**Re: Structural Appraisal Report, Proposed Conversion of Existing Workshop,
Widgeham Barn, Poplar Farm, Fressingfield.**

The discussions and recommendations contained within this report are based upon the proposals as indicated on Hollins Architects drawing 23 64 – 02, dated May 2023.

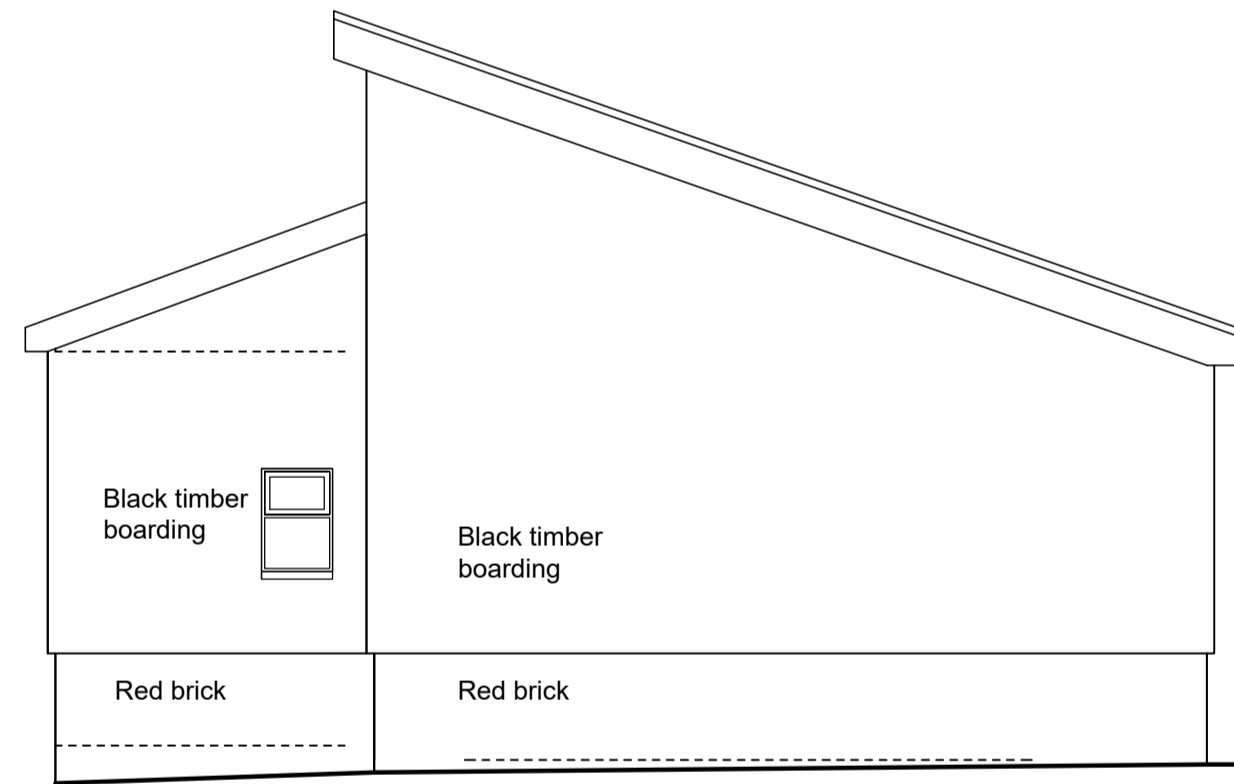
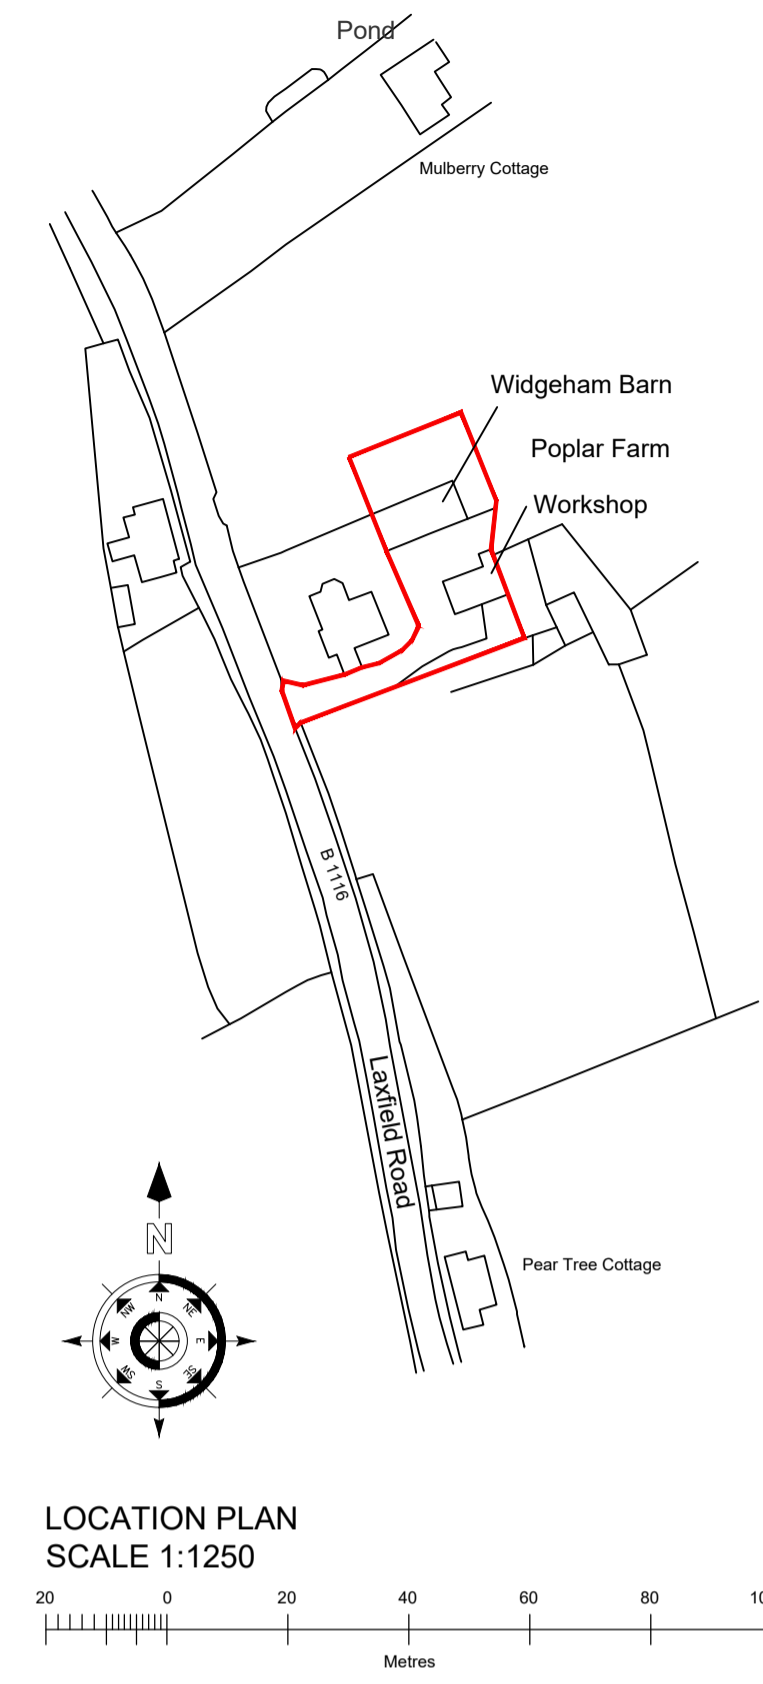
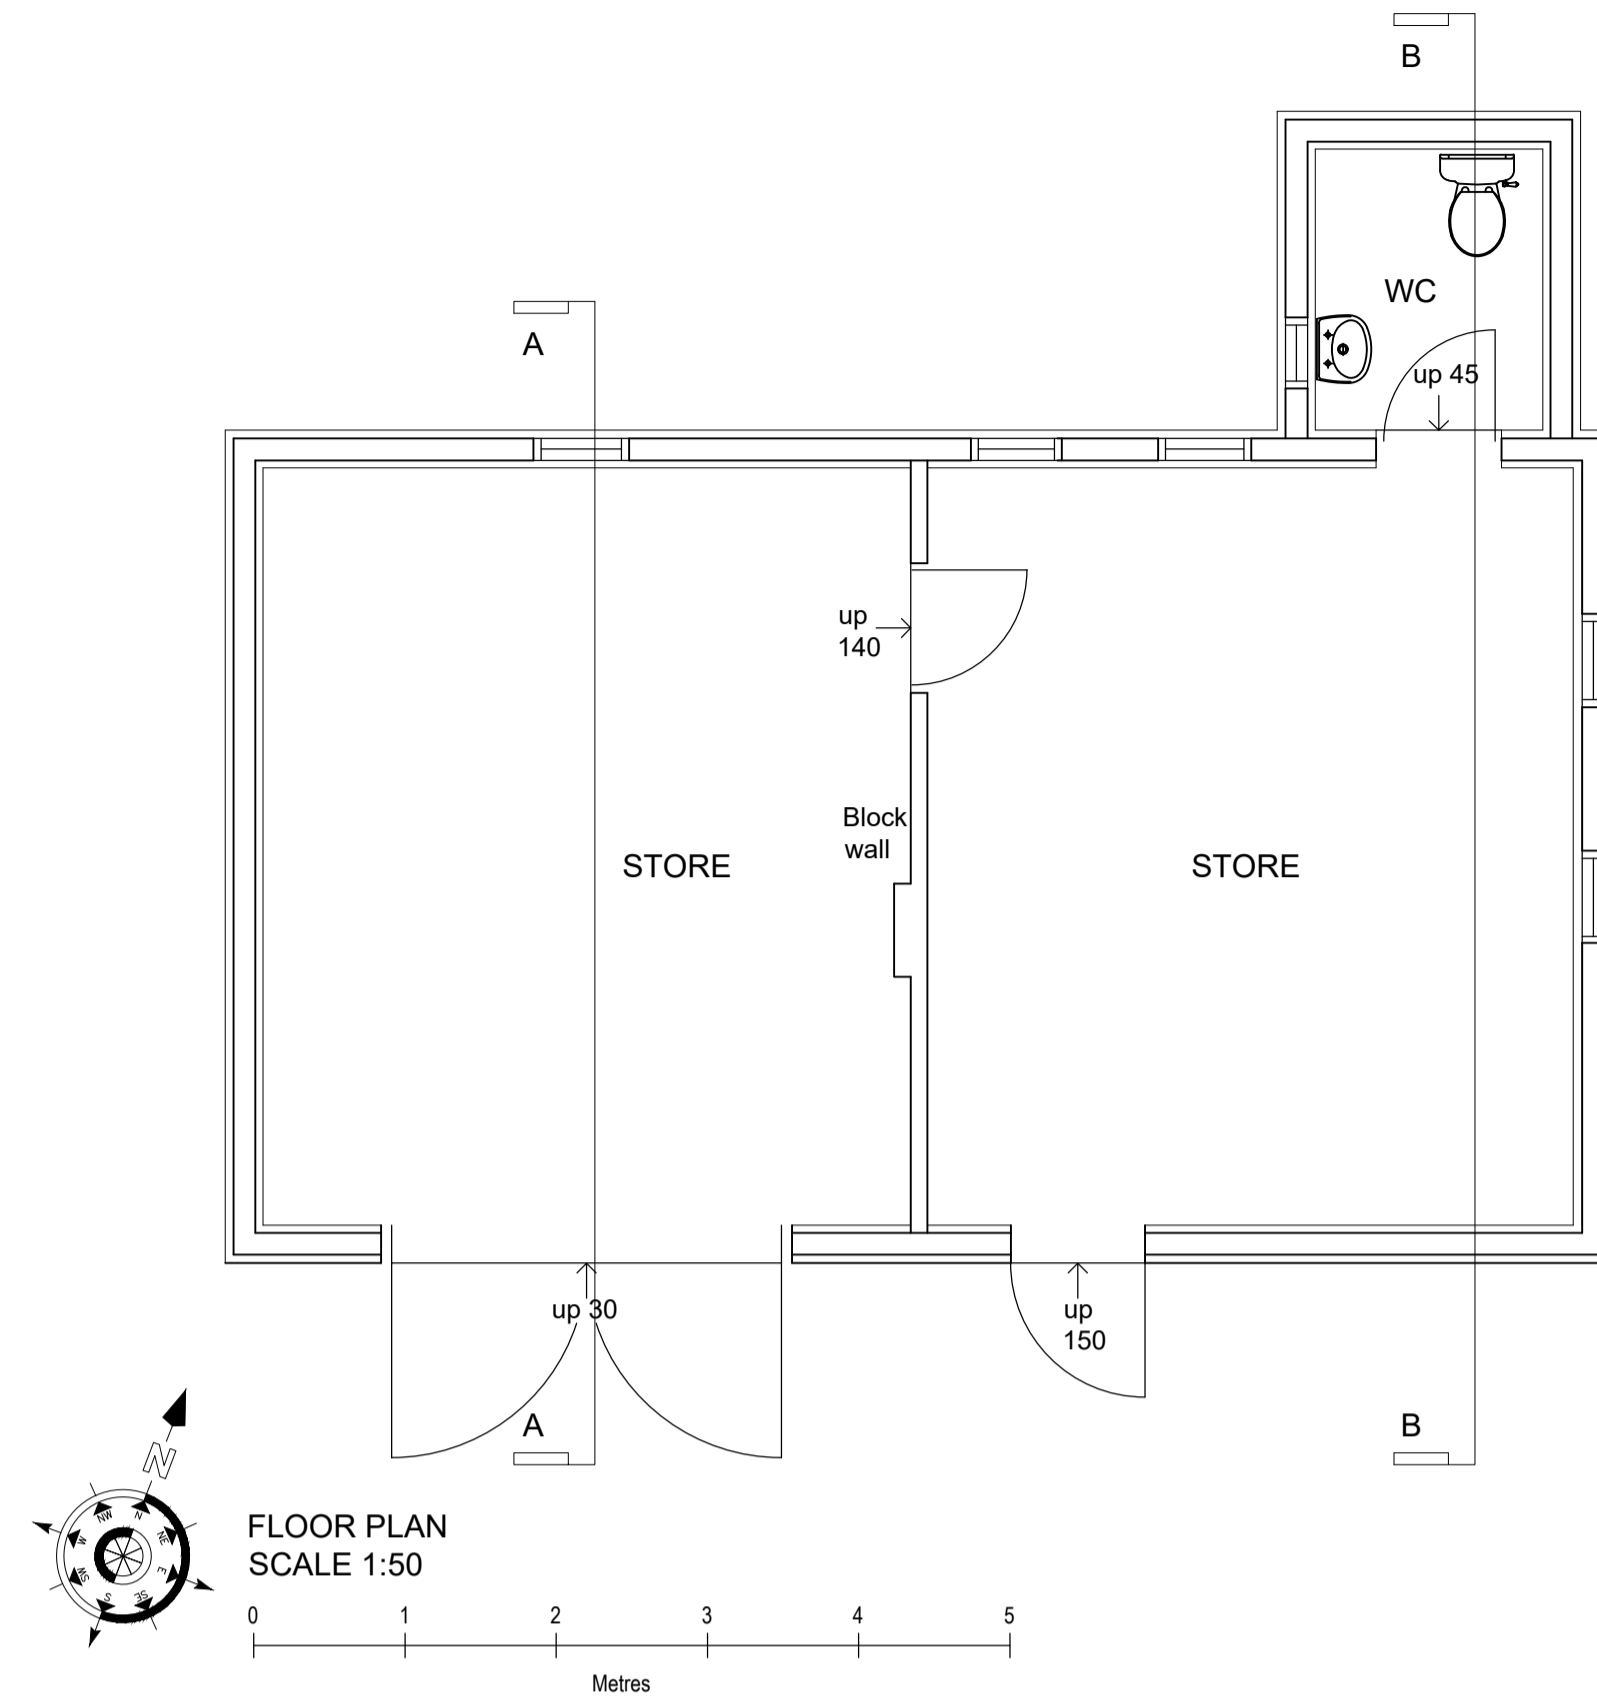
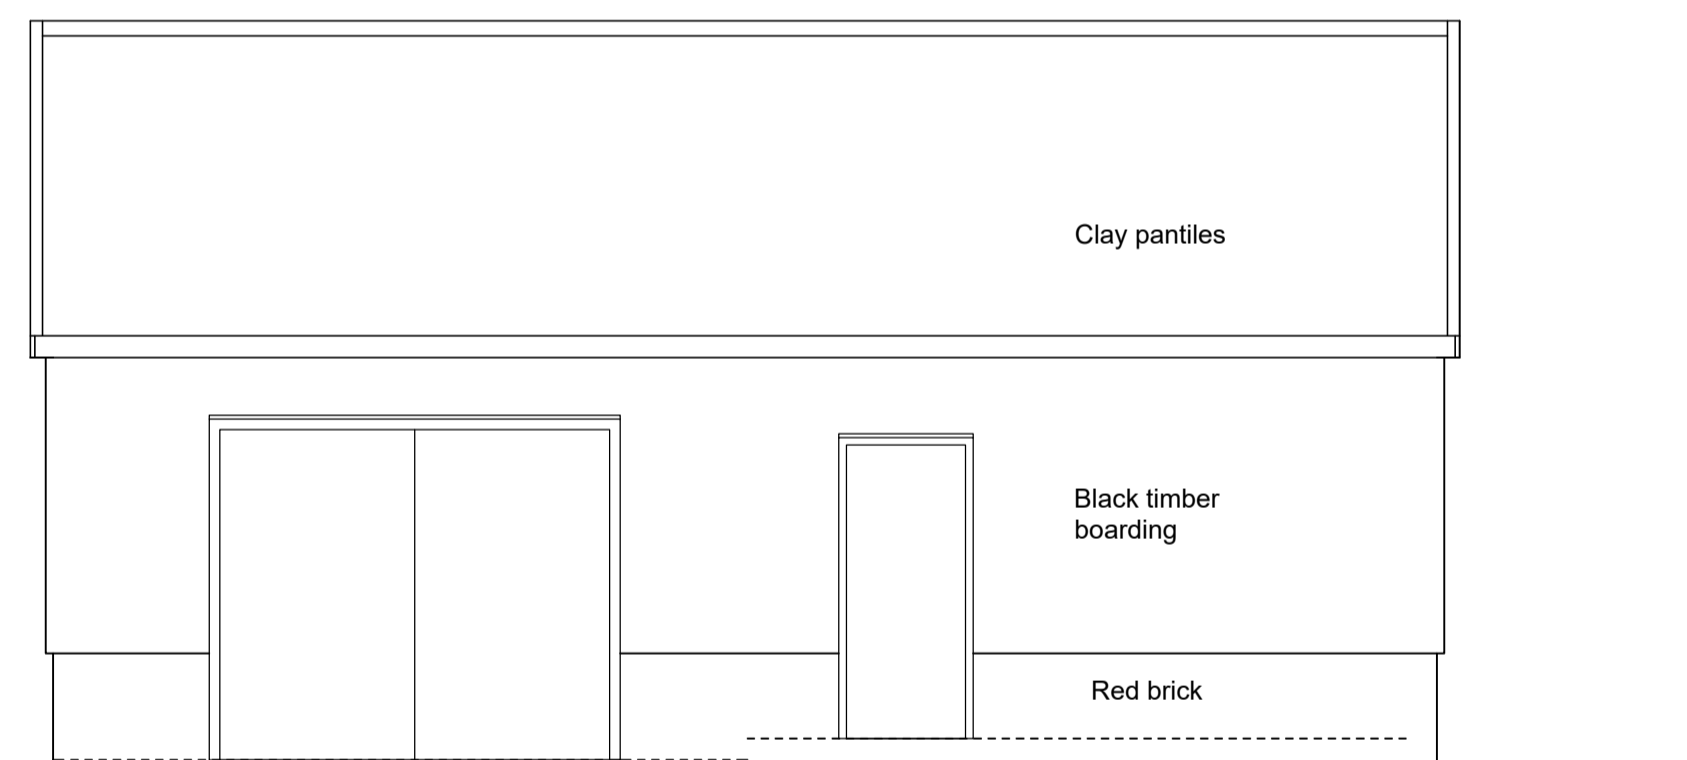
We would comment that it is likely the existing internal masonry wall does not have a foundation, and as such independent would be required to the proposed mezzanine, as opposed to the beam bearing onto the internal wall as currently indicated on the architectural drawings. This should include supporting posts and new concrete pad foundations. We would comment also that whilst there is no evidence of significant movement or cracking within the existing internal masonry wall, the wall would benefit from buttressing to reduce its slenderness. This could be provided by the new partitions abutting the wall, or the adjacent post supporting the mezzanine.

- Provide independent support to the proposed mezzanine floor.
- Provide buttressing to the existing internal wall, utilising either the new partitions or the new post supporting the mezzanine floor.
- Provide additional connection between the top of the west wall and the roof.
- Provide multi-studs each side of the existing double doors.

WEST ELEVATION  
 SCALE 1:50

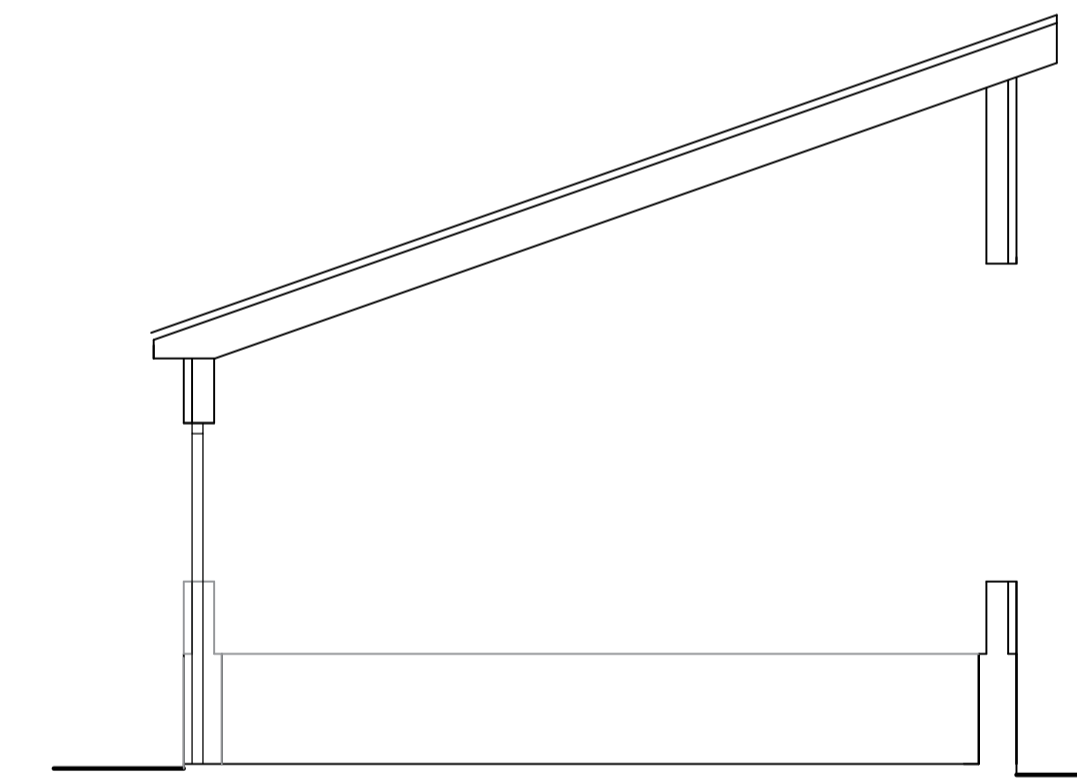
We would also comment that at present there is no clear connection between the top of the west wall and the roof structure. Whilst there is no evidence of movement between the roof and wall, we would consider it prudent to provide timber noggins between the end rafter and the studwork forming the west wall, and to extend the ply sheathing to the underside of the timber rafters as this currently stops short of the wall.
